CHALLENGER HOMES
FALCON HIGHLANDS SOUTH
SITUATED IN SECTION 12, TOWNSHIP 13 SOUTH,
RANGE 65 WEST OF THE SIXTH PRINCIPAL MERIDIAN,
COUNTY OF EL PASO, STATE OF COLORADO
GRADING & EROSION CONTROL PLANS

PCD-ENGINEERING REVIEW COMMENTS
IN BLUE BOXES WITH BLUE TEXT

EPC STORMWATER REVIEW COMMENTS
IN ORANGE BOXES WITH BLACK TEXT

CHALLENGER HOMES
8605 EXPLORER DRIVE
SUITE 250
COLORADO SPRINGS, CO 80920
719-598-5192
JIM BYERS
CHALLENGER HOMES
FALCON HIGHLANDS SOUTH
EL PASO COUNTY, COLORADO
CONSTRUCTION PLANS
GRADING AND EROSION CONTROL PLAN
COVER

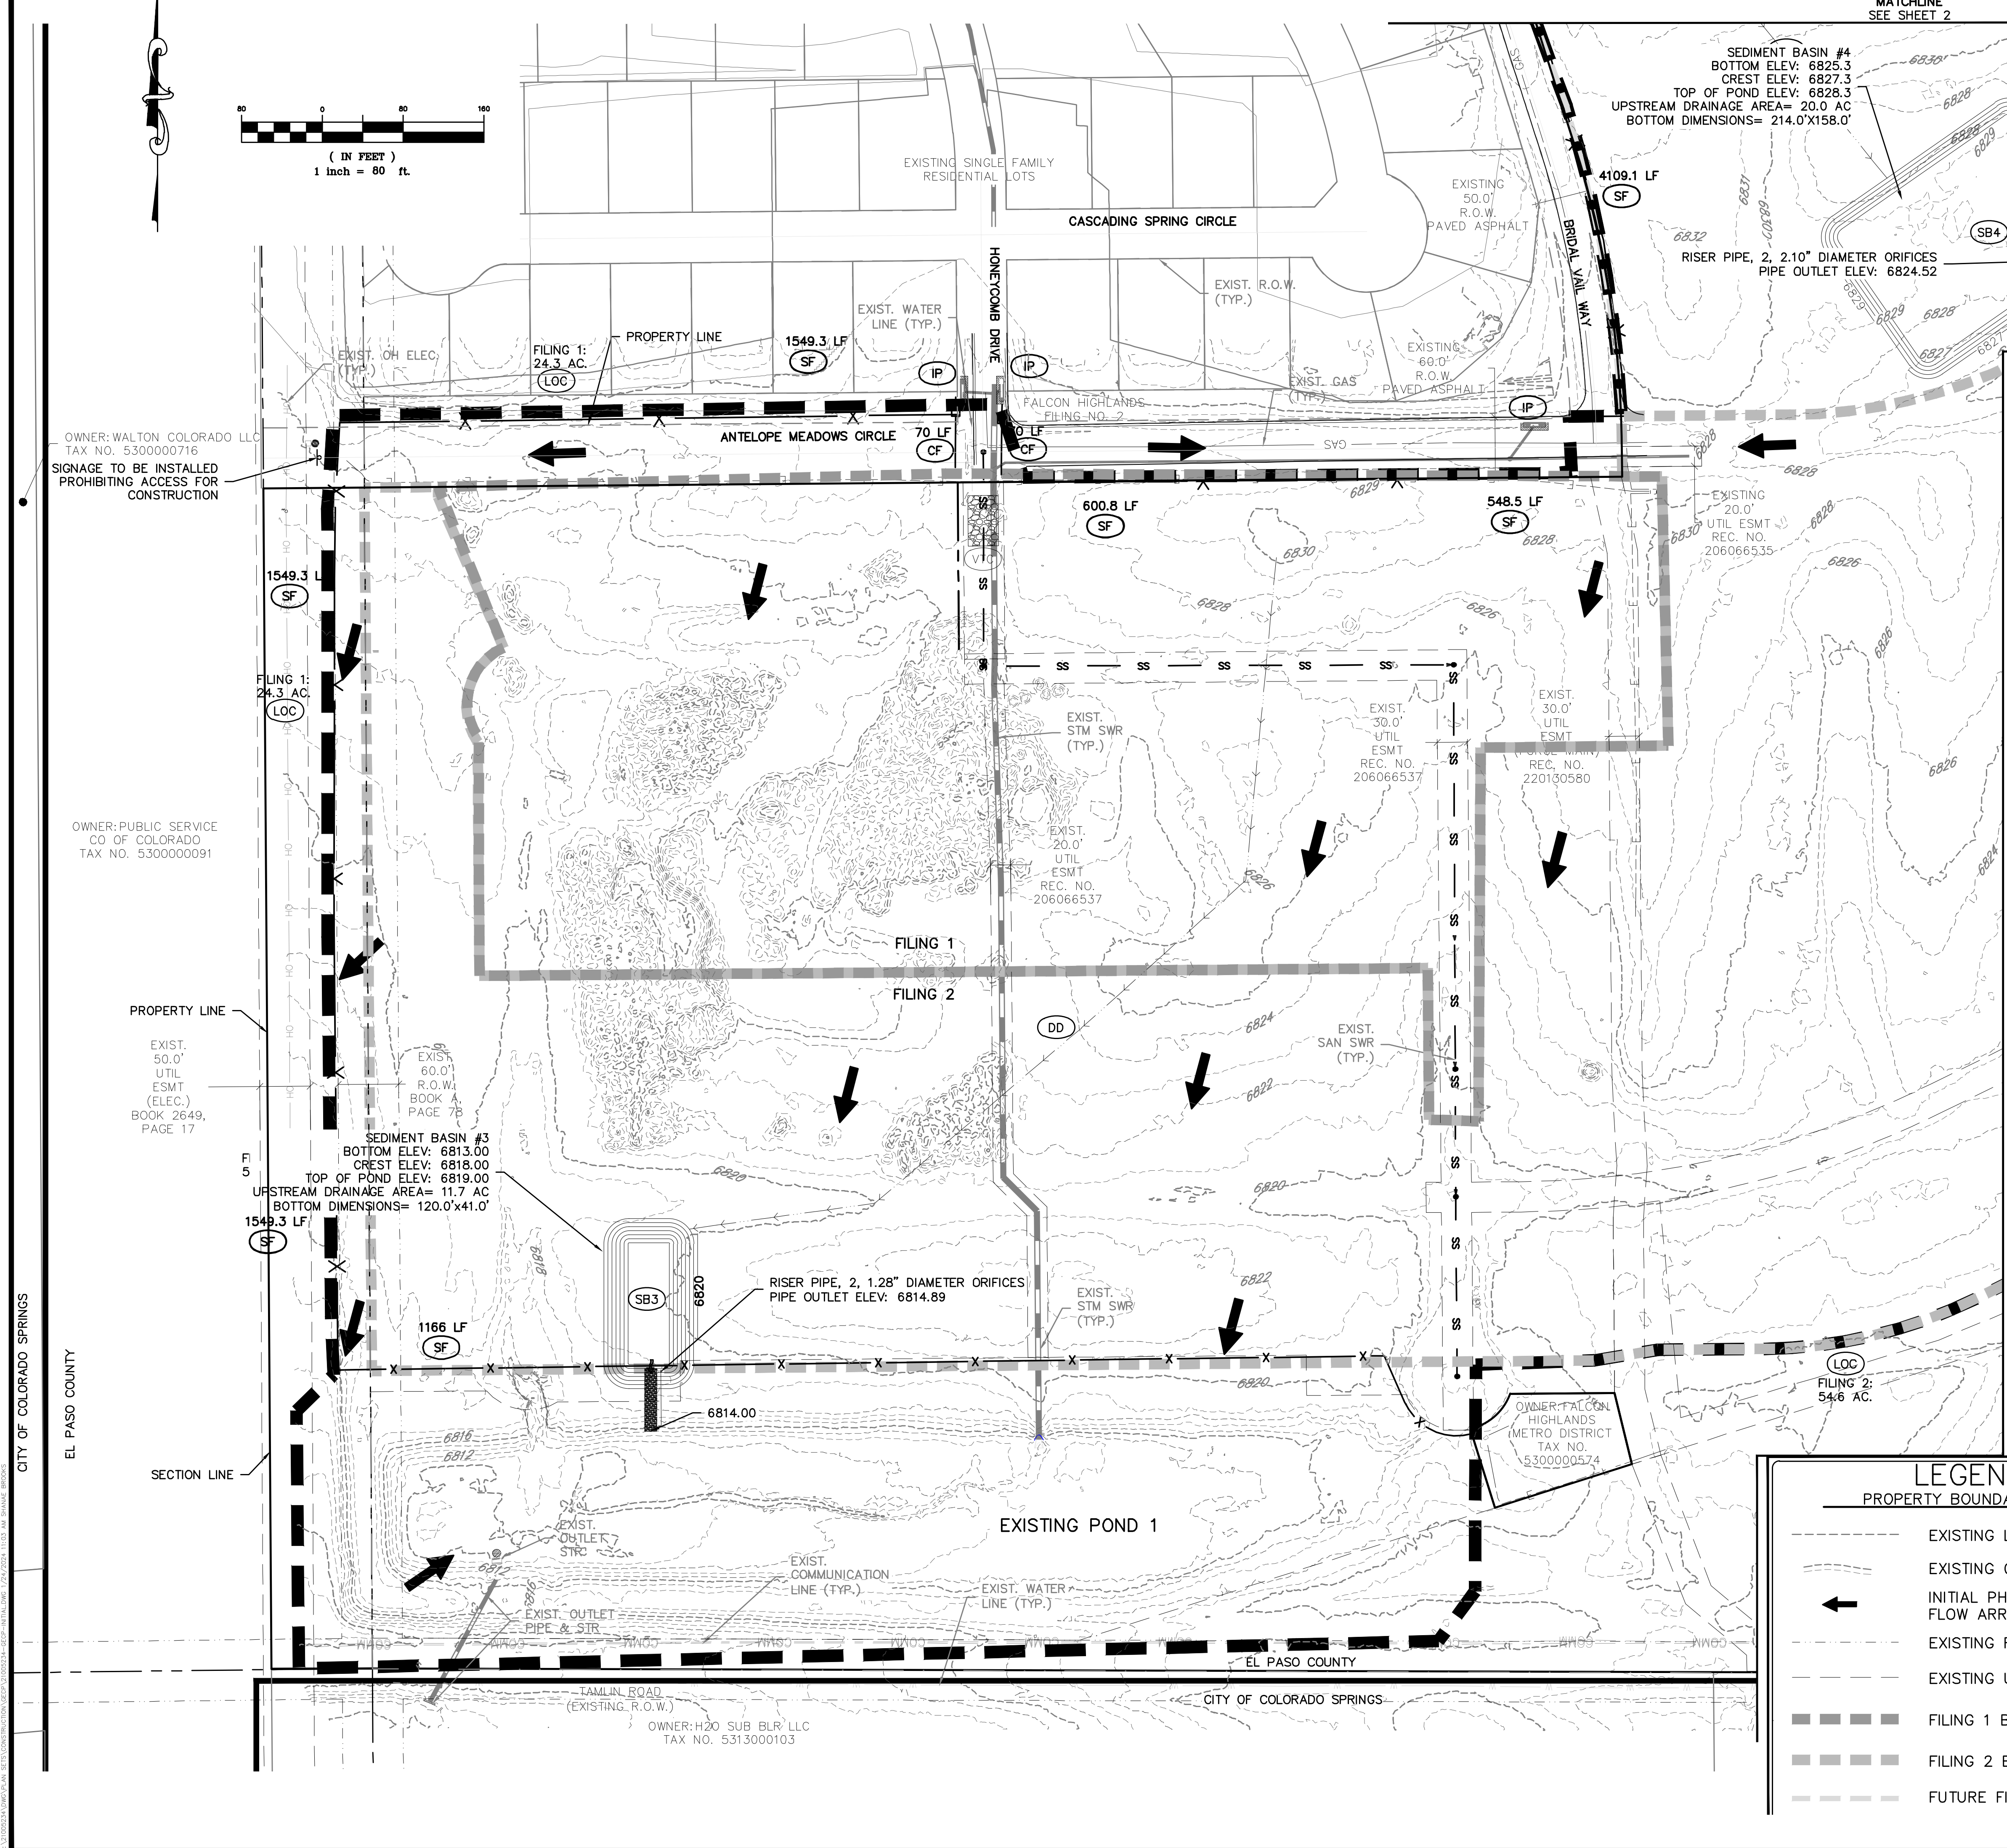
where will this TSB discharge to? show contours, location of spillway and discharge pipe.

where will this TSB discharge to? show contours, location of spillway and discharge pipe.

adjust match line to show all of the TSB

stormwater from this grading area should be treated via a TSB prior to entering the existing pond.

show all existing pond features (inlet, trickle channel, forebay, spillway, etc.)

4

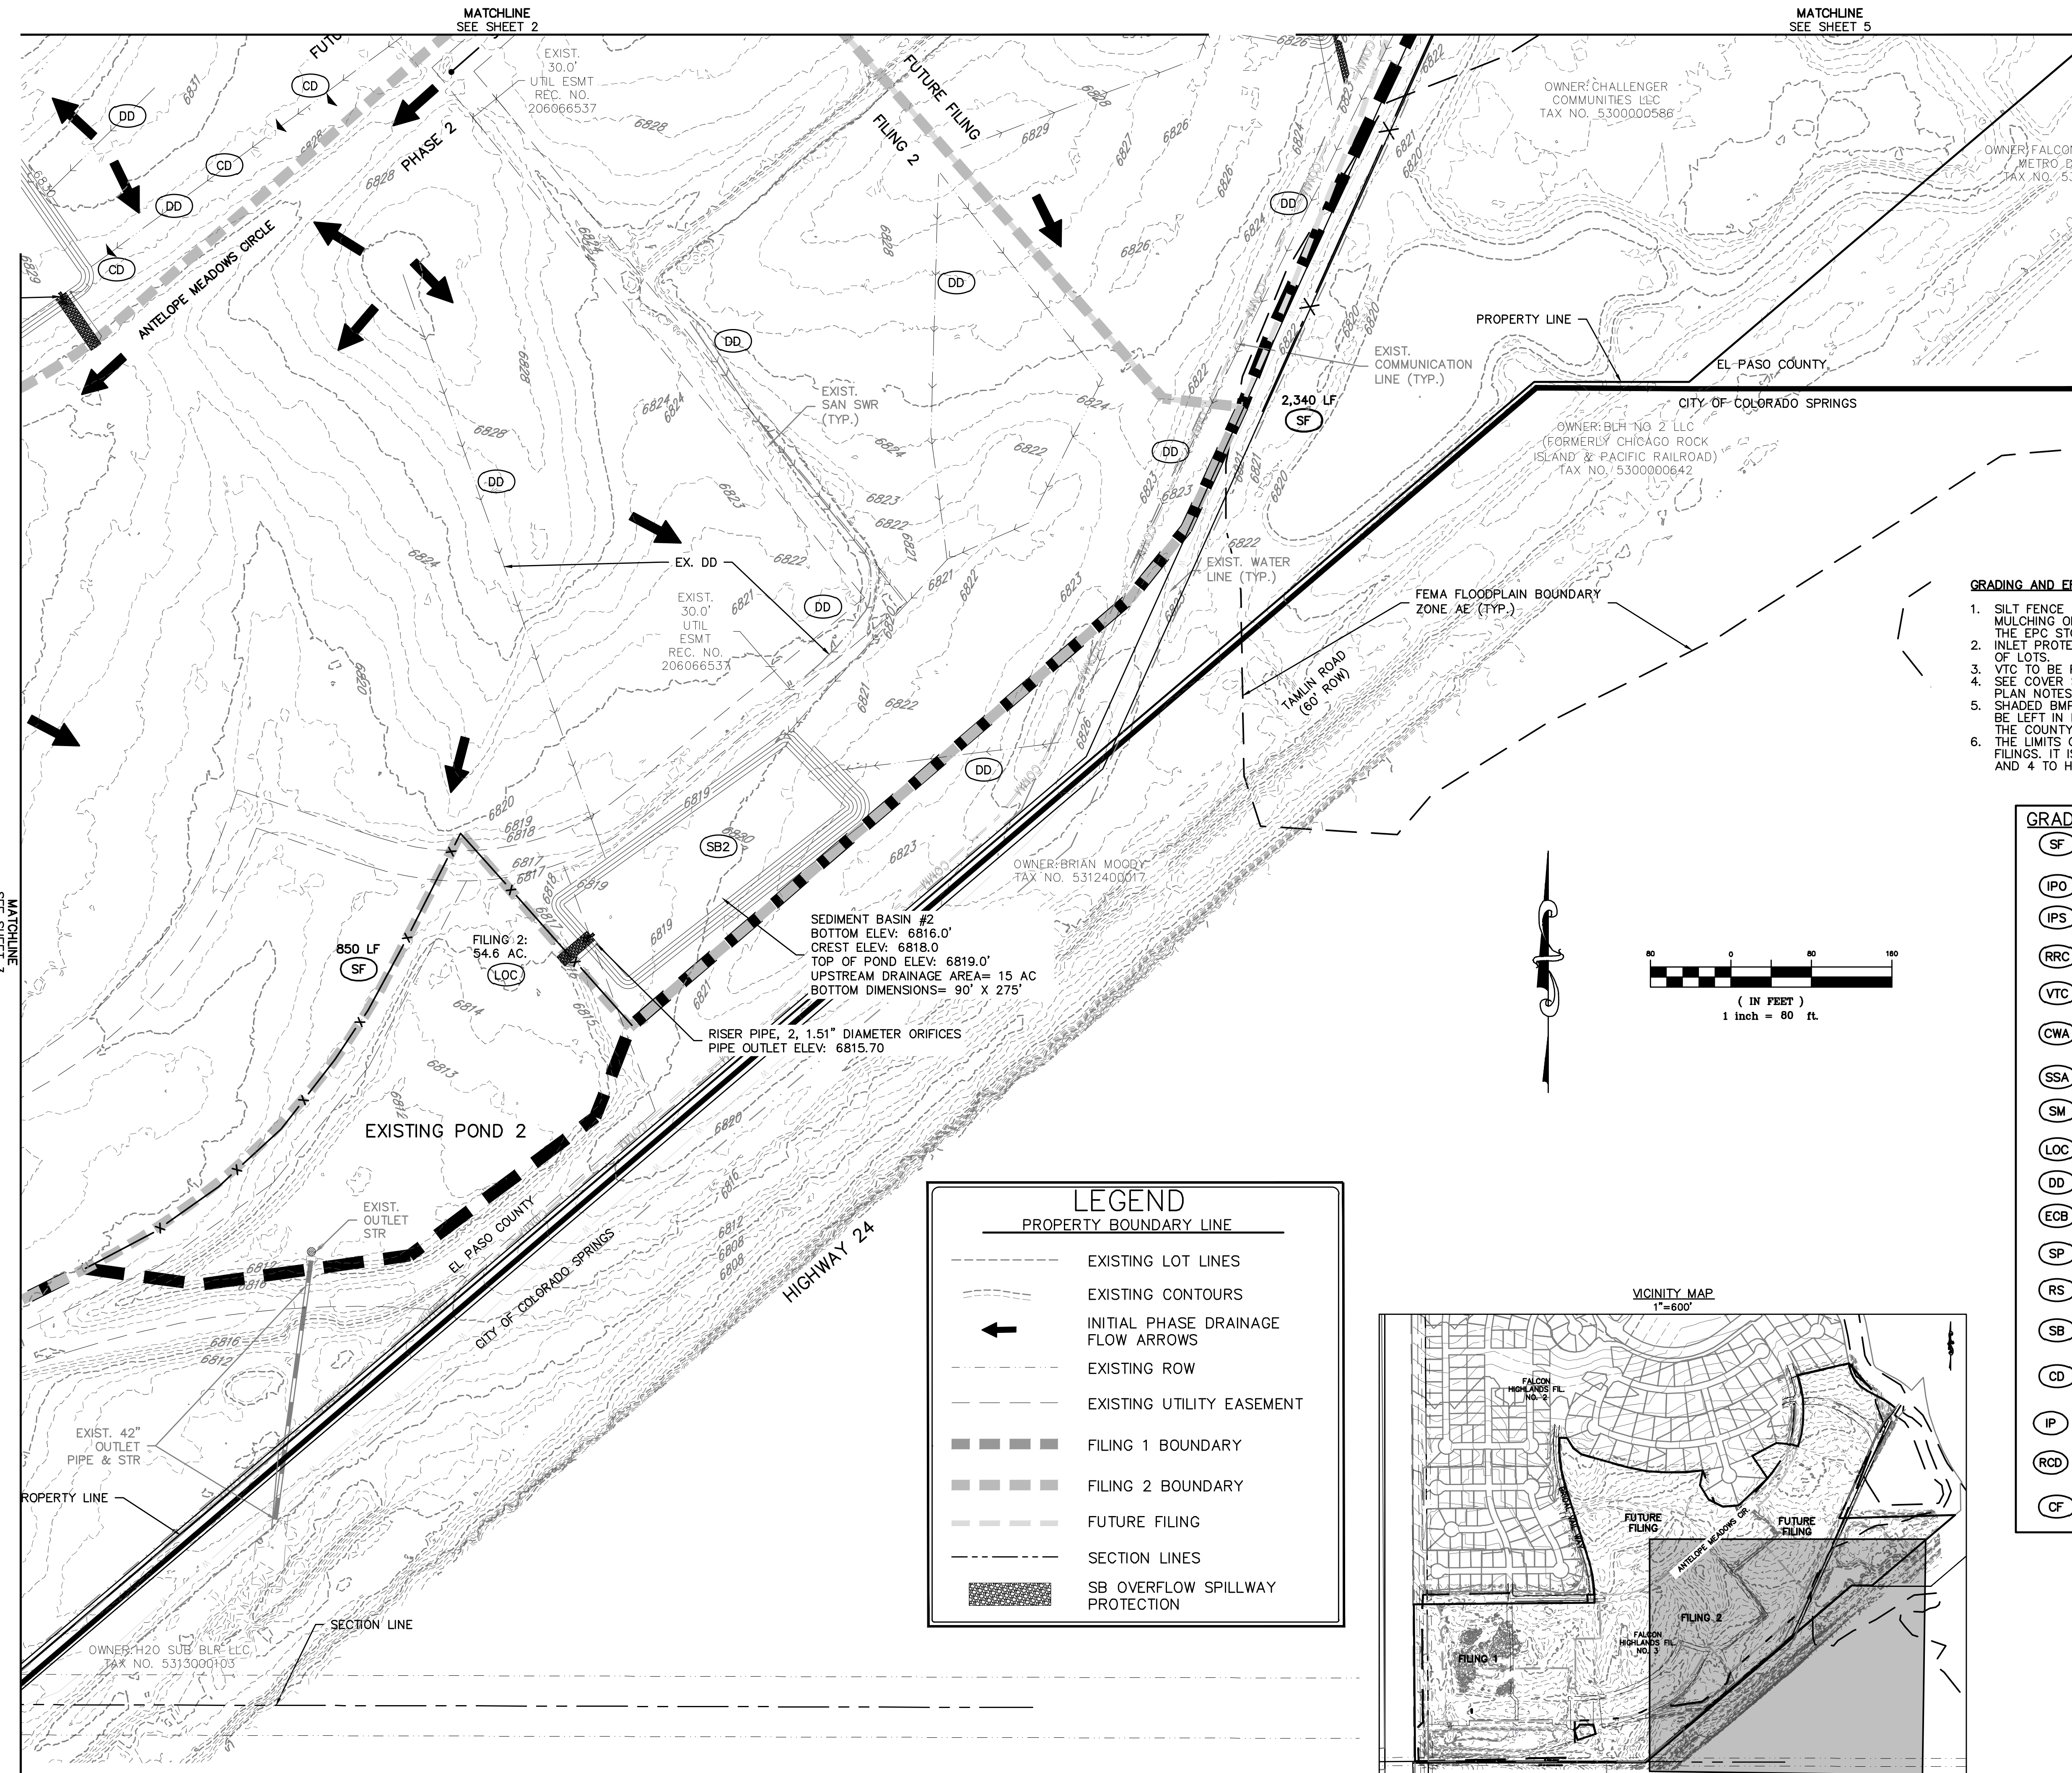
where will this TSB discharge to? show contours, location of spillway and discharge pipe.

stormwater from this grading area should be treated via a TSB prior to entering the existing pond.

show all existing pond features (inlet, trickle channel, forebay, spillway, etc.)

is this ditch existing, as described in the DR? If so, show existing contours

continue DD to TSB
